<b>Consultation Response from KC, Conservation &amp; Design</b>
<b>2023/92490 Former Dowker Works, Dowker Street, Milnsbridge, Huddersfield, HD3 4JX</b>
<b>Erection of 35 dwellings with associated access and landscaping (within a Conservation Area)</b>
<b>Date Responded: 20.9.2024</b>
<b>Responding Officer: Sue Brooks</b>
<b>Responding Ref:</b>
<p>Following the previous Conservation and Design consultation response dated 13 October 2023 and subsequent negotiations, amendments have been made to the proposal. We have the following comments on the revised proposal:</p> <ul style="list-style-type: none"> <li>Of particular concern was the proposed use of reconstituted stone on the elevations facing outside the site (George Street, Dowker Street and Armitage Road) where the predominant character is natural stone. We recommended that natural coursed stone was proposed for these elevations as well as retaining and boundary walls for exposed areas adjacent shared spaces and boundaries. Type 1, 3 and 4 cottages, and plots 9 - 13 have been amended to show natural stone front elevations and gables, with ashlar stone heads and cills. Cottage Flats Type 2 drawings show reconstituted stone on the

DESCRIPTION:
3B4P House Type 1 Elevations

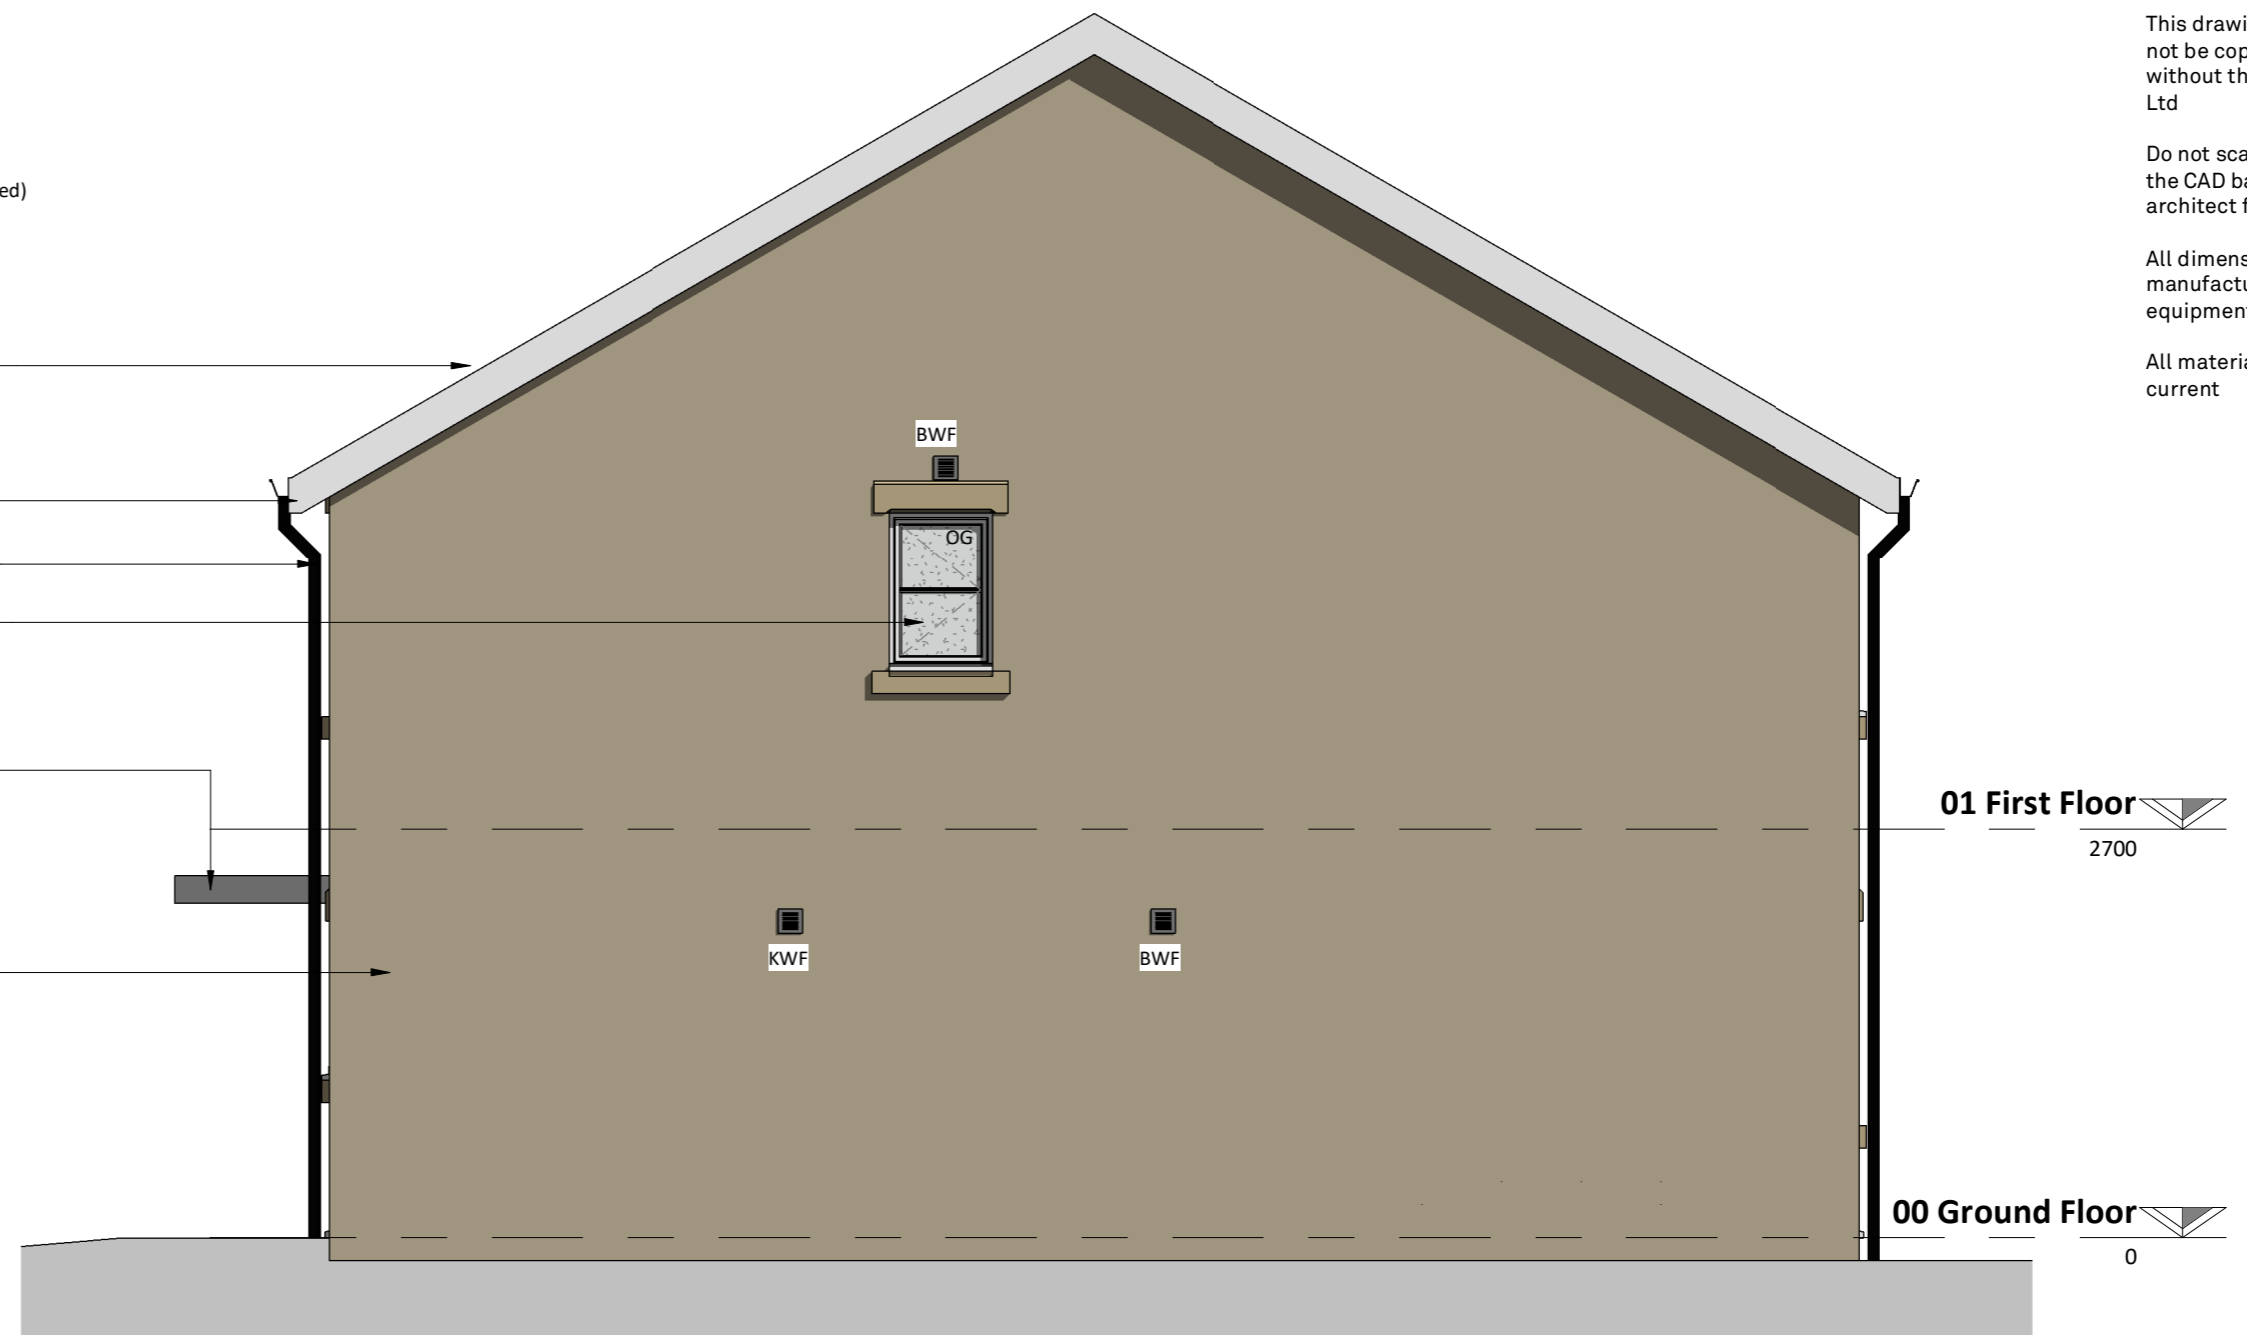
- Air Source Heat Pumps – details, size and locations have not been submitted and should be located on rear elevations.

We would recommend that a condition is applied requiring location and design to be submitted for approval.
